From: Zac Denton
Sent: 20 February 2019 09:03
To: Karen Parsons
Subject: FW: 25 Stewards Rise , Arundel BN18 9ER

My Team Leader has flagged up an error in the submitted plans, with regard to the labels on the aspects of the elevations. Is there any chance this can be fixed?

REV	DRAWN	DATE	DESCRIPTION
CLIENT			
SITE ADDRESS			
25 Stewards Rise Arundel West Sussex BN18 9ER			
DRAWING TITLE			
Proposed Extension & Alterations Proposed Plans and Elevations			
SCALE			
As shown			
DATE			
August 2018			
REFERENCE			
25 Stewards Rise			
DRAWING No.		REV.	
002

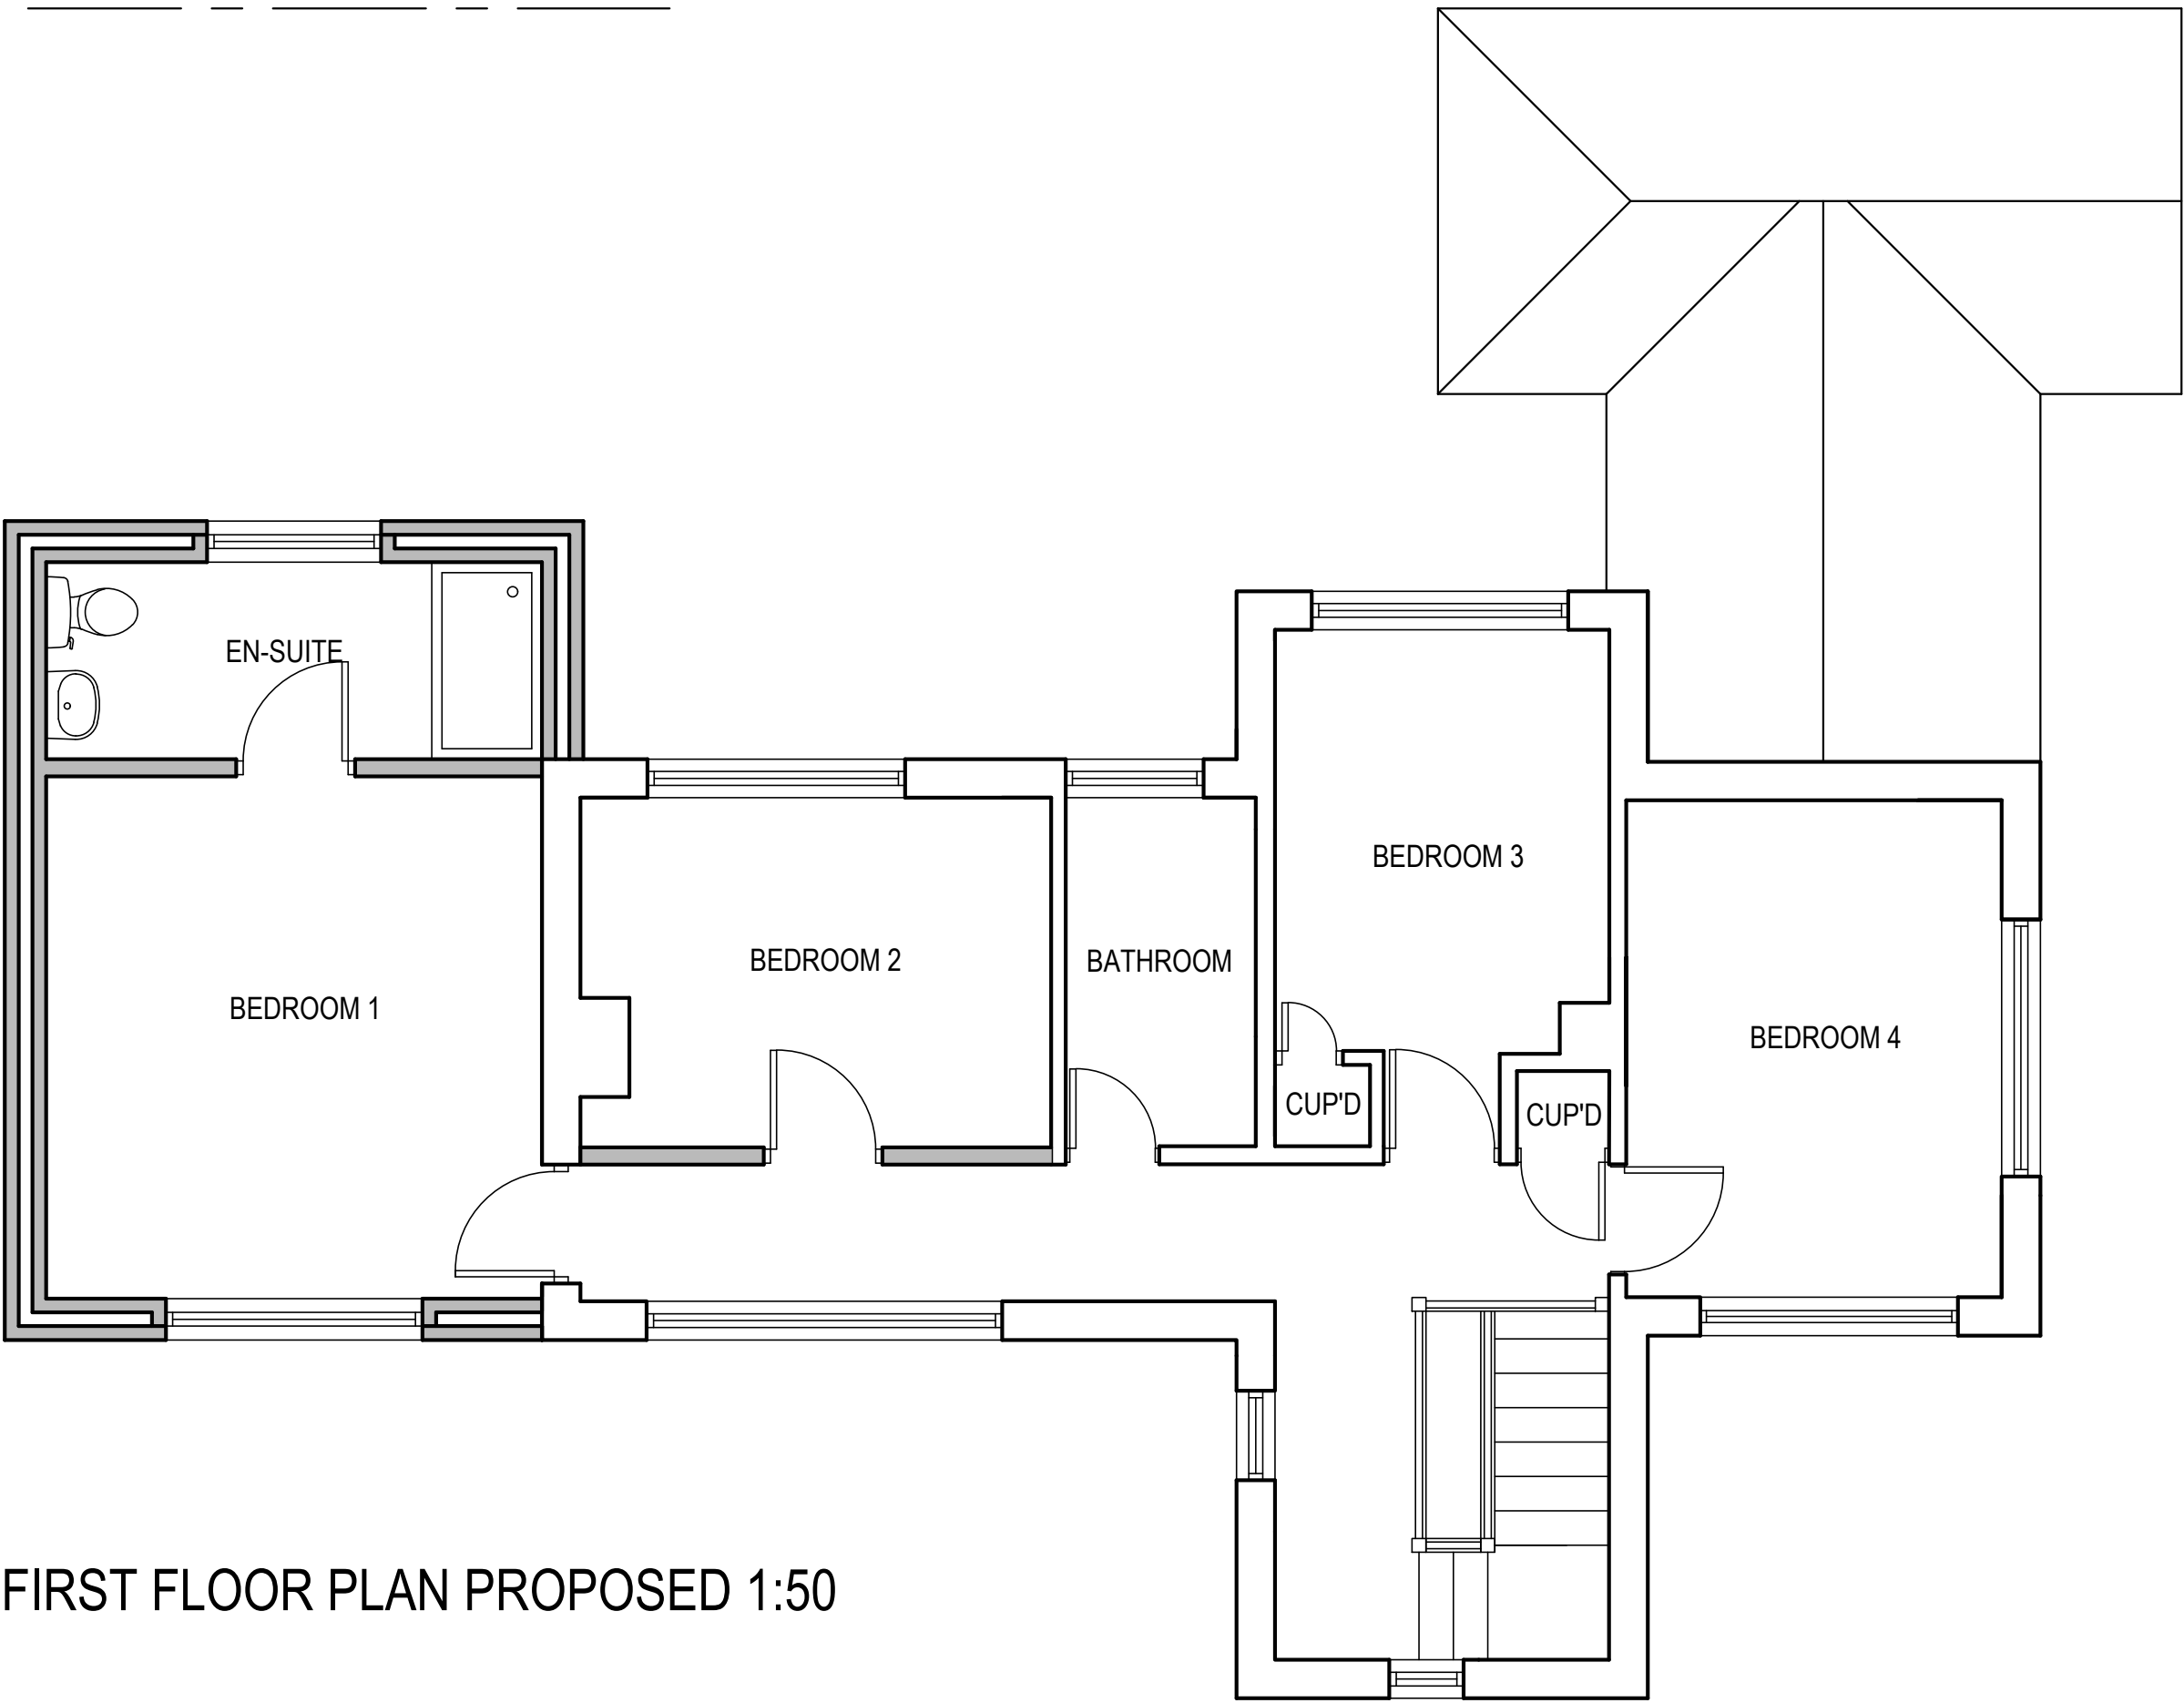
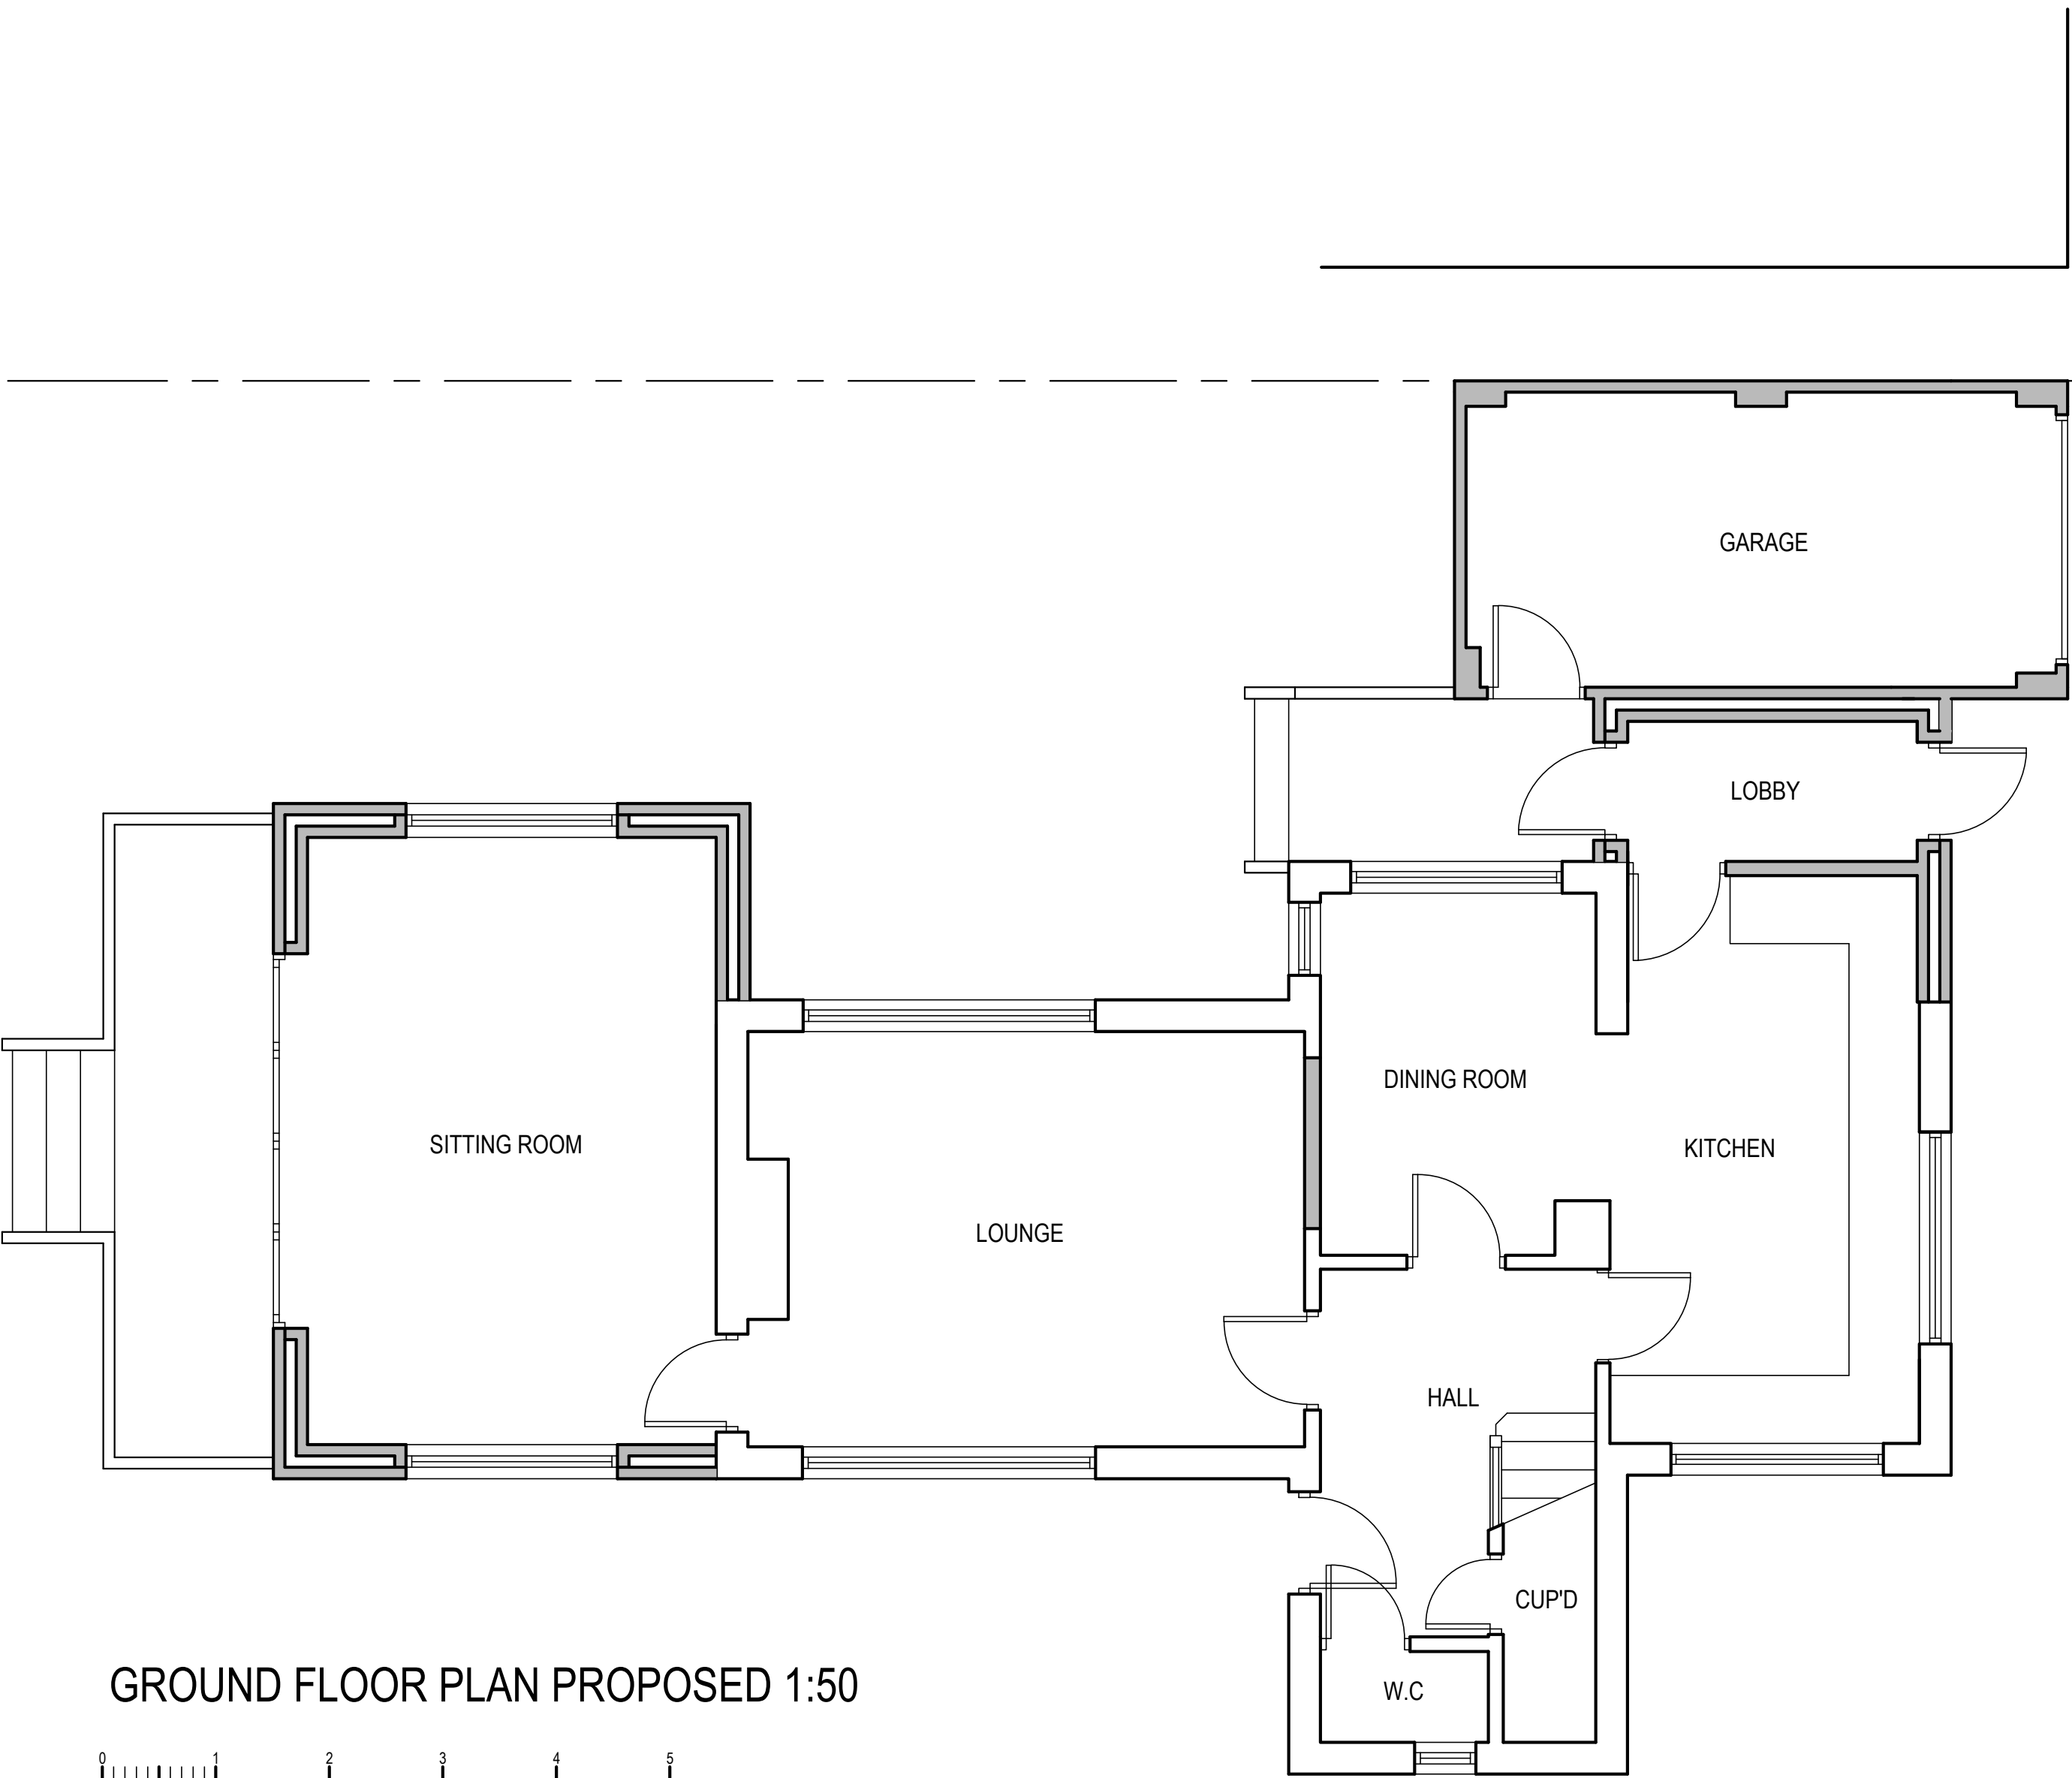
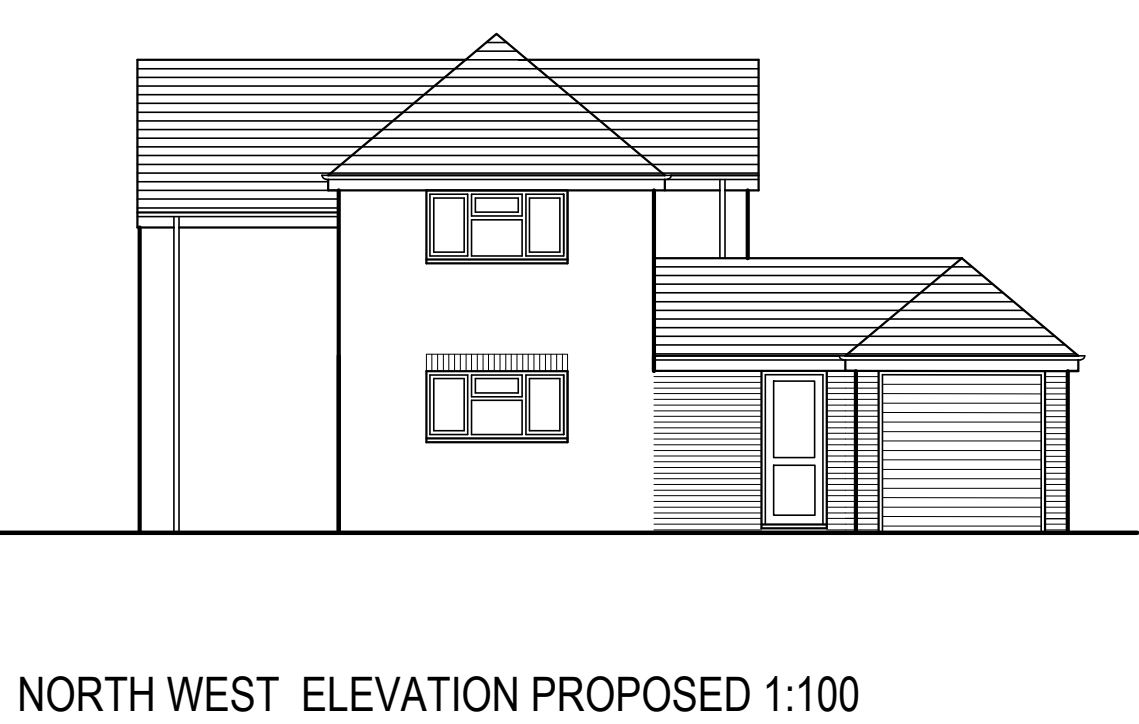
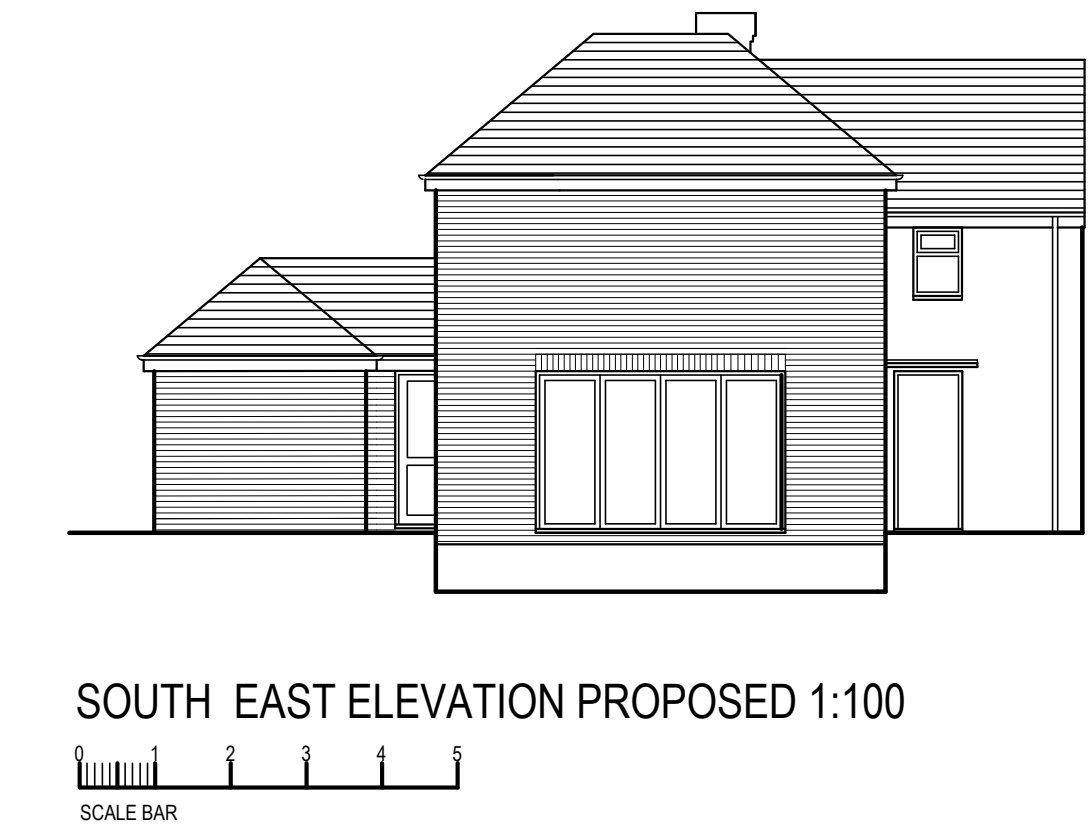
The elevation indicated as 'South' needs to be 'East'. 'East' needs to be 'North' and 'North' needs to be 'South'.
